Suggested location for Inspector's site visit – The British Horse Society

Pertenhall BW 26 and Bolnhurst & Keysoe BW 37 (APP-121 Masterplan sheets d and c, APP-010 Streetworks plan sheets 1, 2 and 3, APP-160 Outline PROW mgmt plan and APP-070 Visual Receptors Figure 5-4a)

Drawing Title
**Street Works, Rights of Way and Access Plan
(Sheet 1 of 14)**

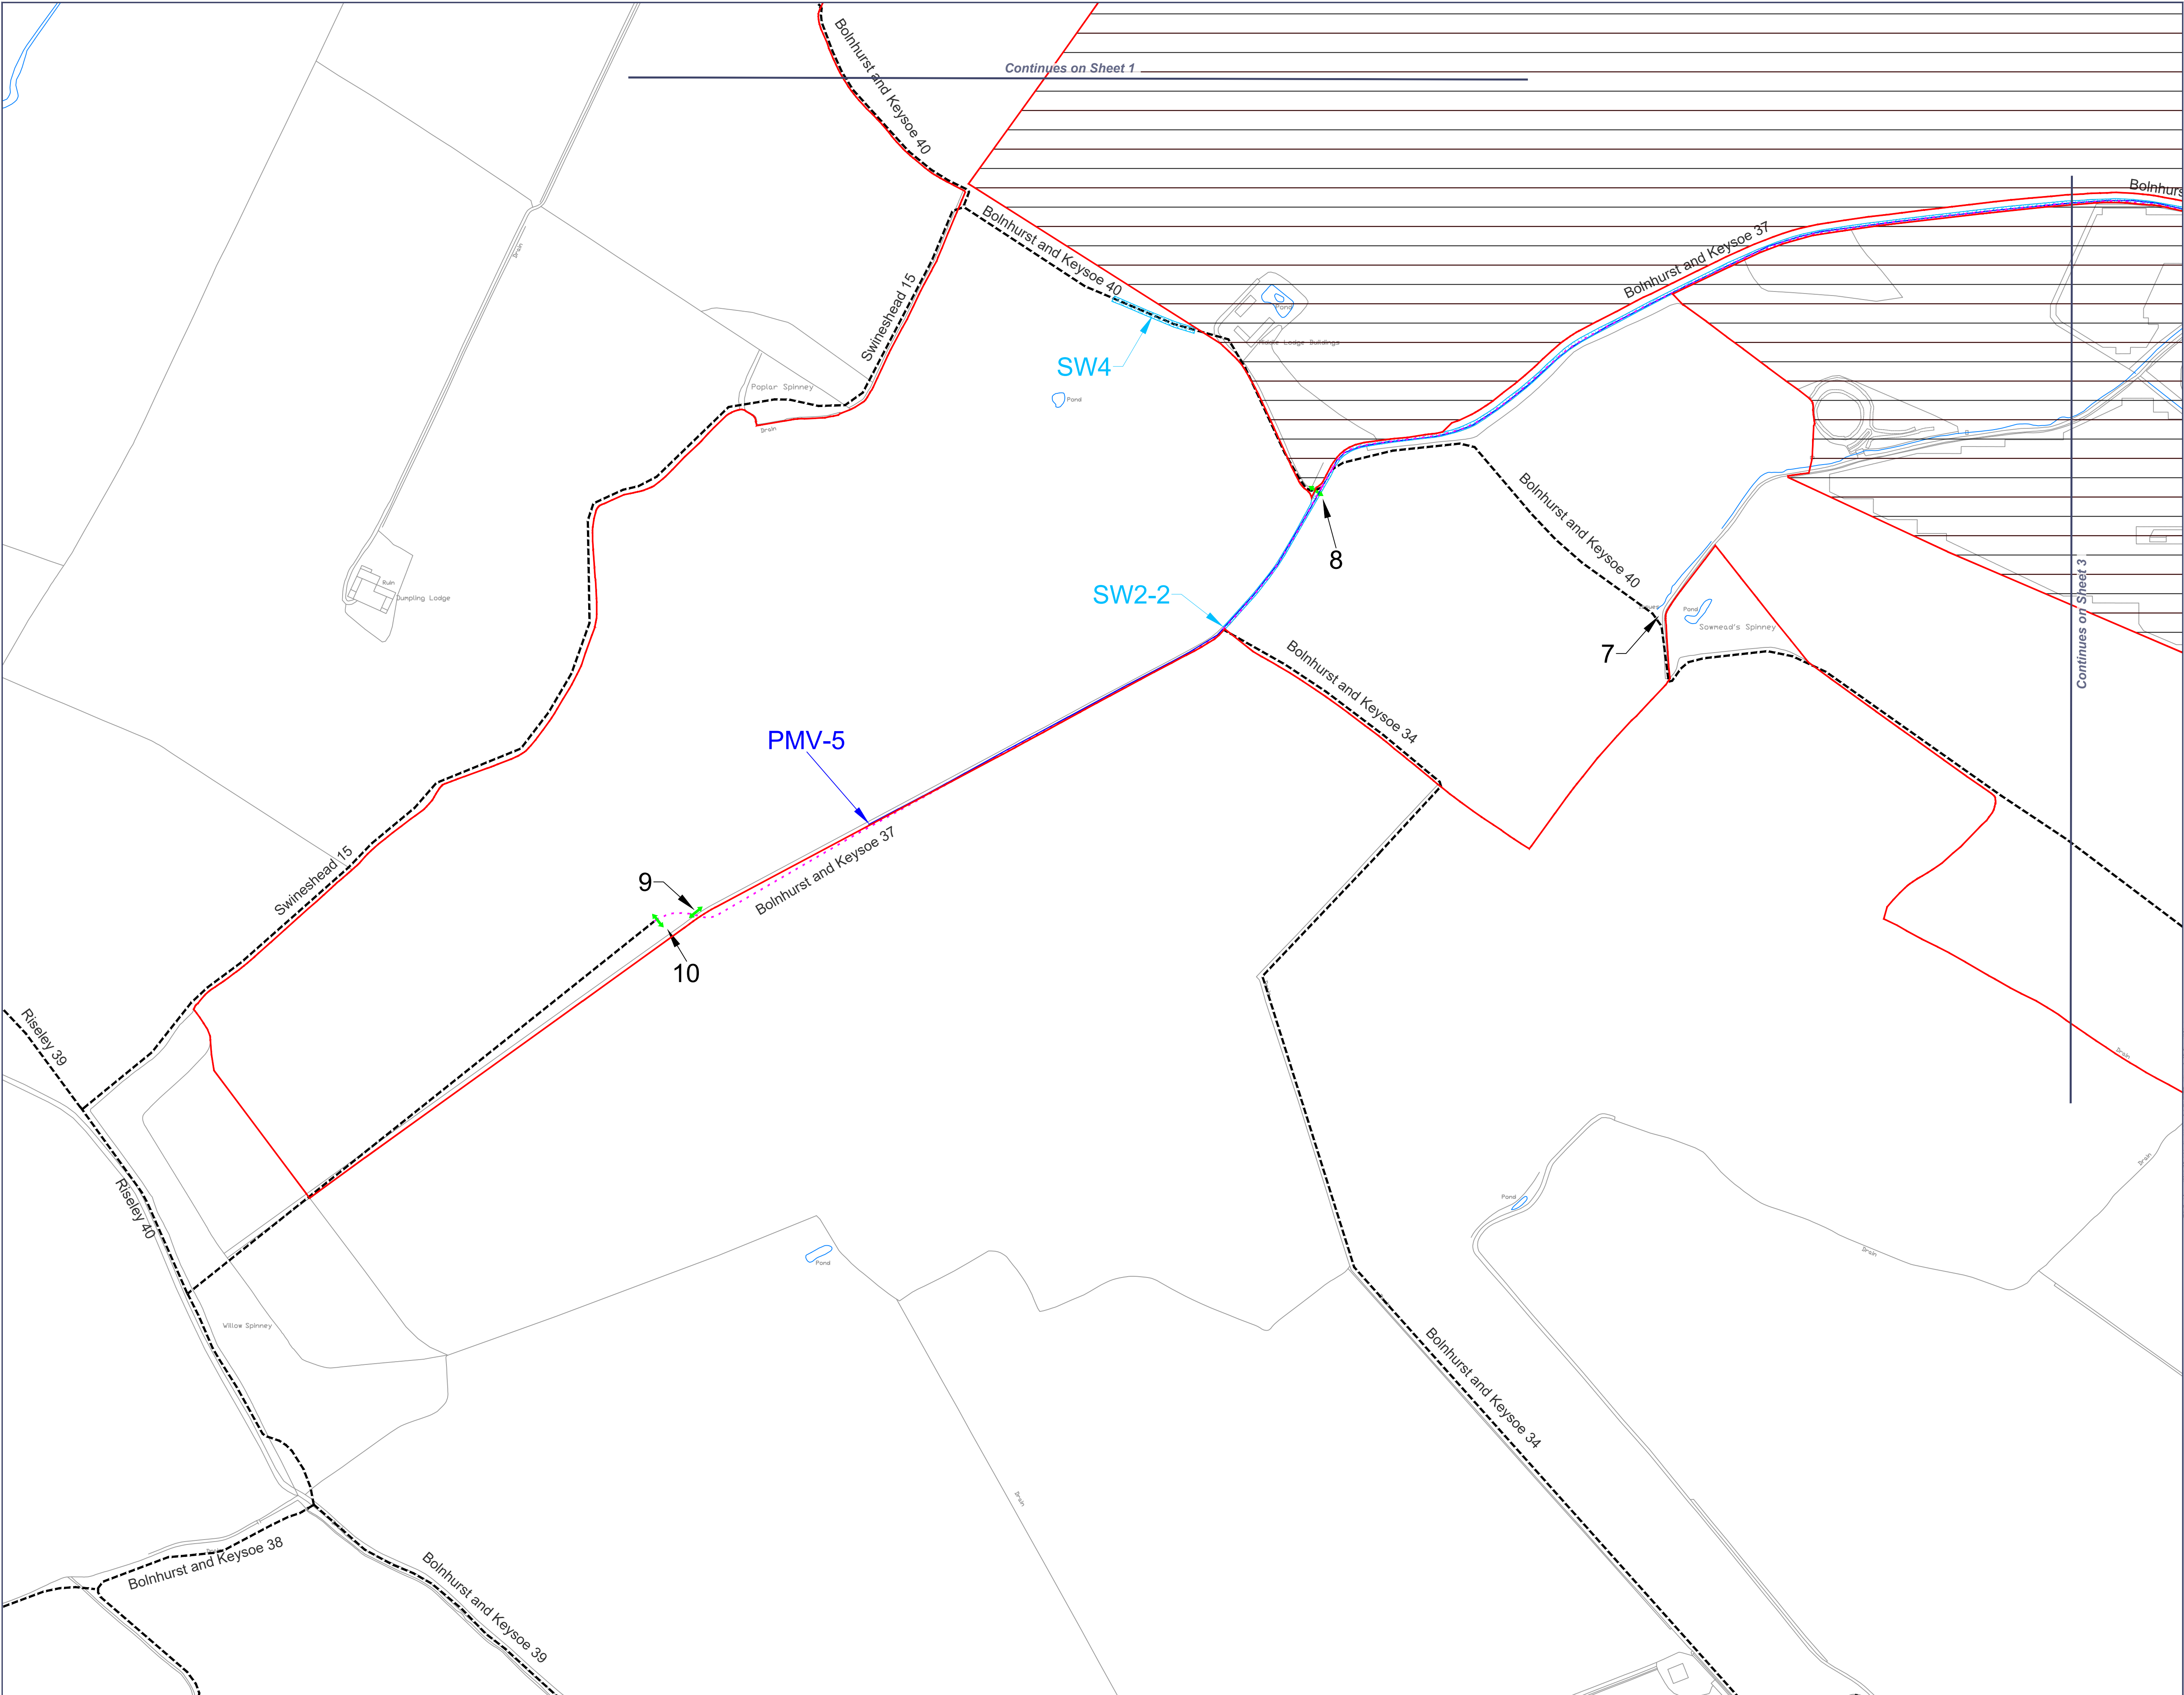
In Manor Farm farmyard, the bridleway will be shared with construction traffic. The oPROWMP (section 6.4) notes that, during construction, bridleway users continue to use the existing bridleway track and verges but that “temporary fencing could be used segregate them from construction traffic”.

There are two pinch points where we do not consider there is enough space to achieve safe segregation. We ask that the Inspector looks carefully at both these points – shown as A and B on this extract from APP-010 sheet 1:

We ask that the Inspector then looks on the other side of the hedge behind the ditch to see that an alternative, safer headland route can be provided (albeit on land outside the red line but in the ownership of Manor Farm).
